CITY OF ALBUQUERQUE

December 13, 2022

Re: Pima Medical Institute/ New Classroom Building
4400 Cutler Ave. NE
30-Day Temporary Certificate of Occupancy
Transportation Development Final Inspection
Architect's Stamp dated 04-26-22 (H17-D054B)
Certification dated 10-12-22

2 H.C. Ramp Detail
Scale: Not To Scale (Isometric) FOR INFORMATION ONLY

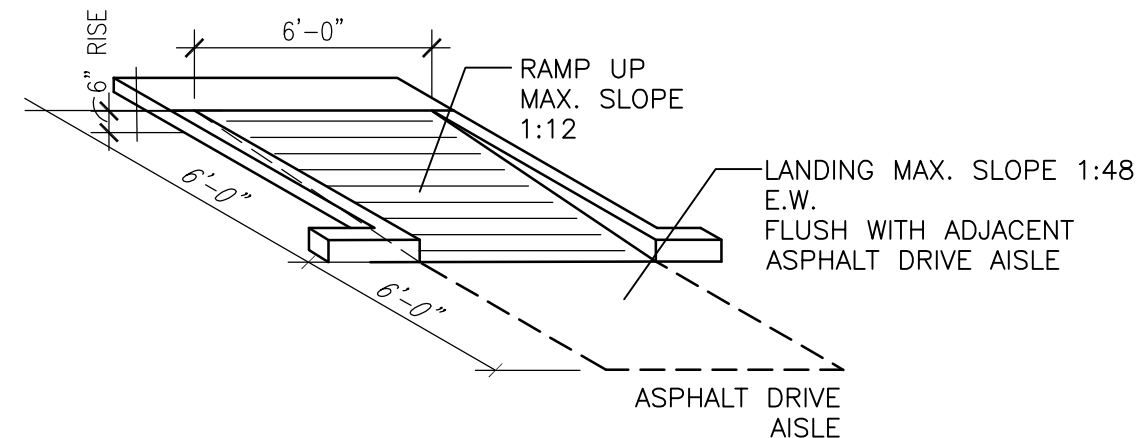
- Keynote 9: per site visit the running slope for the ADA ramp was 9.5%. Per ADA requirements the running slope should not exceed 8.3% (7% preferred slope).
- Keynote 11: Please provide Motorcycle parking spaces per approved plan.
- Keynote 39: Per approved TCL, please provide 6 ft. wide crosswalk.
- Prior to final Certification of Occupancy, please provide City sidewalk easement.
